**Nationally Significant Infrastructure Project: EN010149
Springwell Solar farm**

**Response to The Examining Authority's written questions and requests for
information (ExQ2) issued on 2 September 2025**

Prepared by Lincolnshire County Council (LCC)

September 2025

Figure 2: Indicative construction timelines of all NSIPs and Major Development Schemes considered for potential Interrelationships

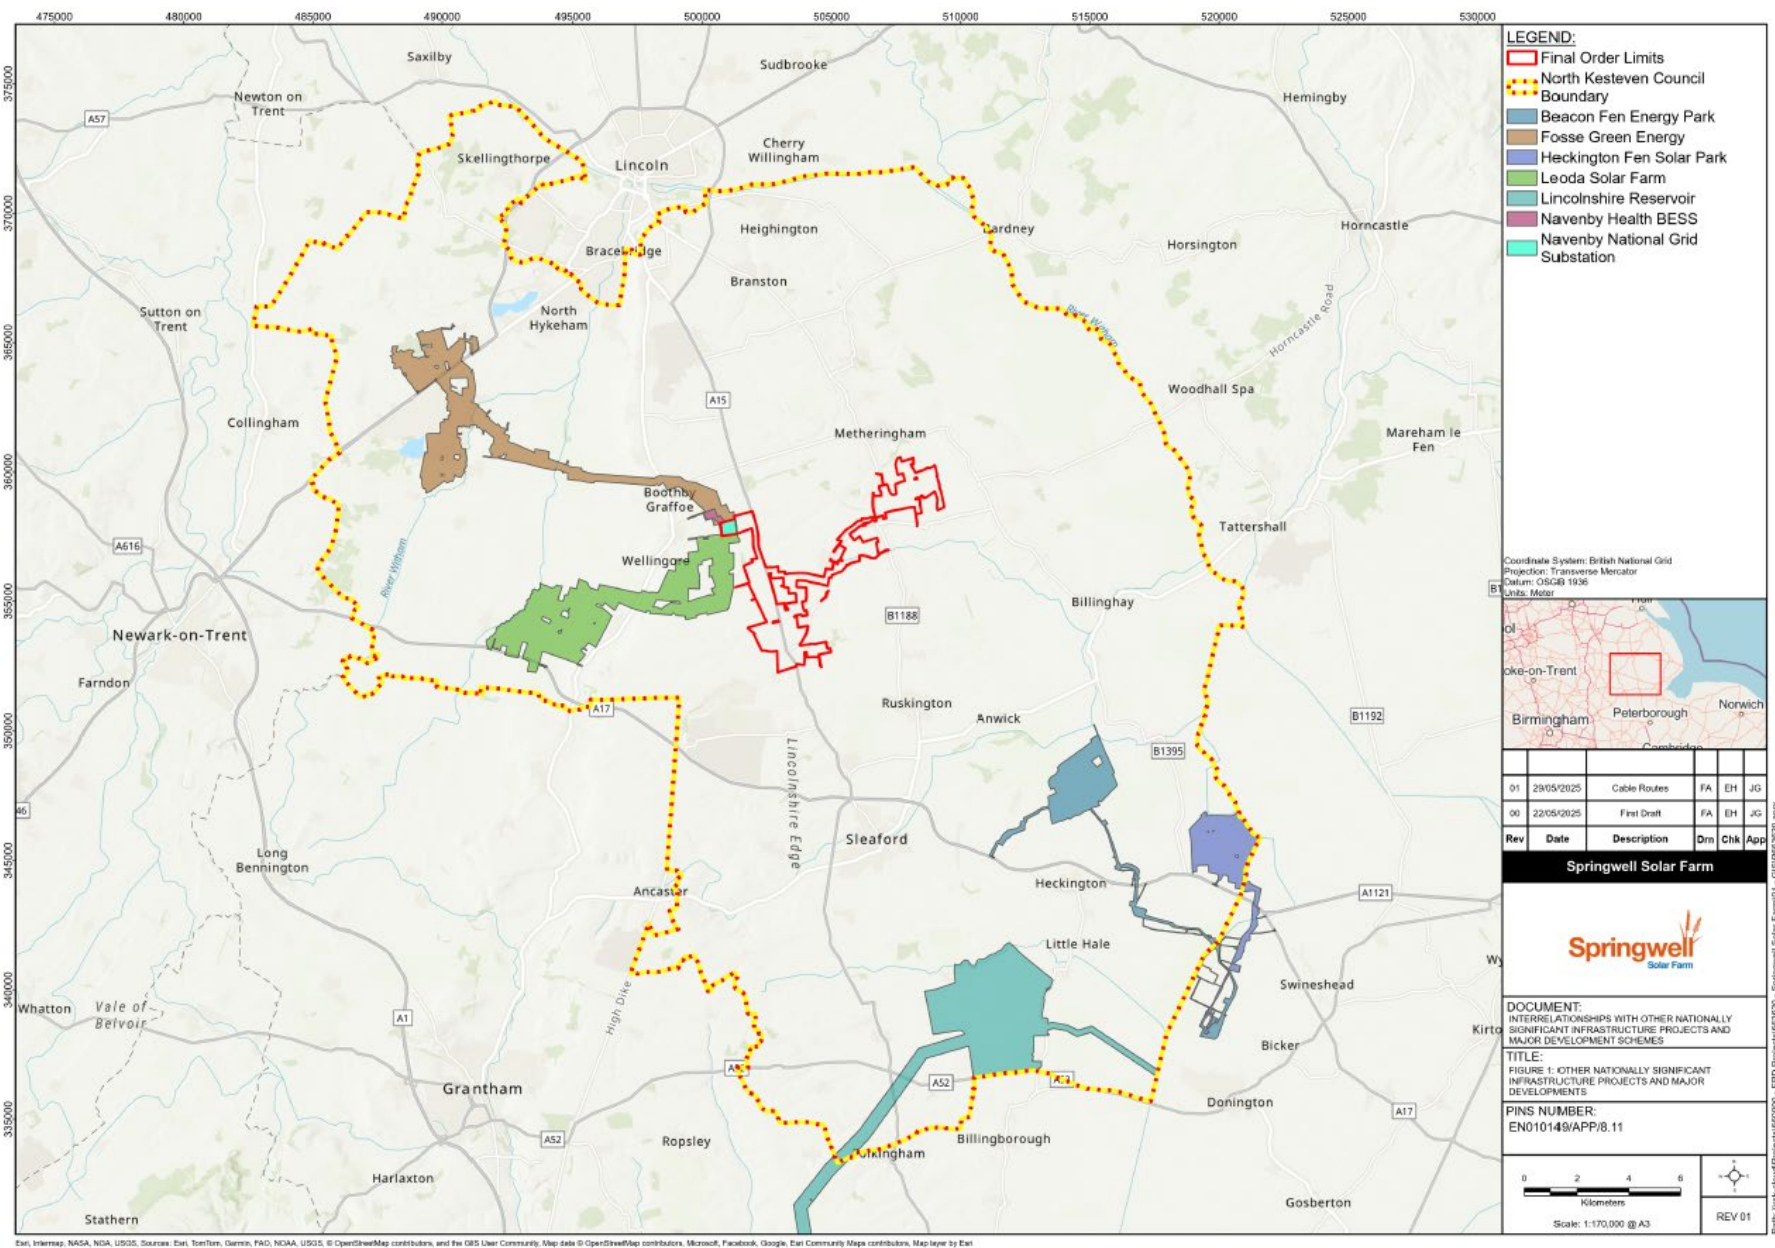
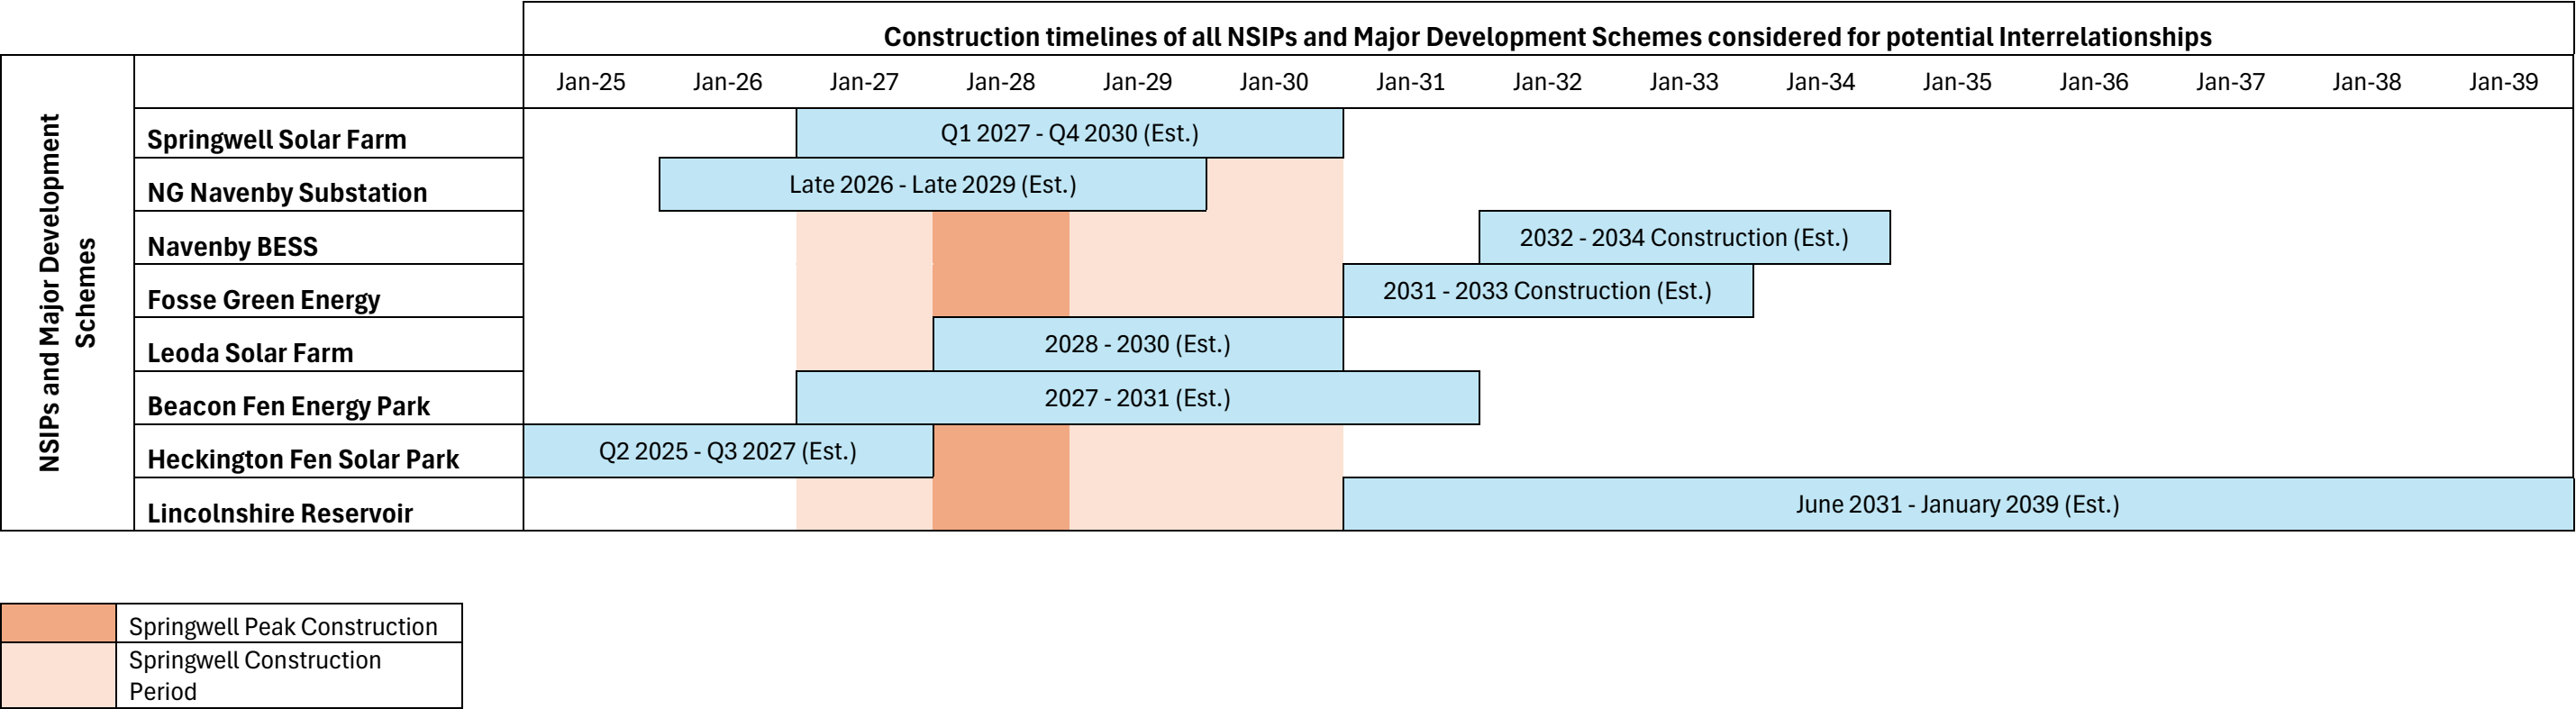
ExQ2	Question	LCC Response
		<p>The applicant has shared an updated draft of the interrelationship report with the Council and the following feedback to the applicant on the draft document was provided:</p> <p><i>As noted at paragraph 1.1.2 of the report it is acknowledged that the current assessment of interrelationships is based on the best available but limited information at this early stage. The commitment to ongoing engagement and collaboration at 1.1.3 is therefore welcomed.</i></p> <p><i>Paragraph 2.1.6 Need for cooperation agreements</i> <i>The Applicant position that there isn't an immediate need to enter into a cooperation agreement due to timescales is noted. This could result in missed opportunities to minimise impacts and negative cumulative effects, particularly with Navenby Substation and Leoda solar farm, where their construction periods all overlap with the 'peak' construction period of Springwell, in addition to all the construction periods of Fosse Green, Leoda and Navenby Substation mostly occurring entirely simultaneously with Springwell. The commitment to exploring the opportunity to enter into a cooperation agreement with other developers, should the need for this arise is however welcomed.</i></p> <p><i>Overall, we remain concerned about statements and conclusions within the report stating that cumulative impacts would be minimal, particularly in light of overlapping construction periods.</i></p> <p>LCC will provide further comments at deadline 5 once it has had an opportunity to review the submitted document at deadline 4.</p>
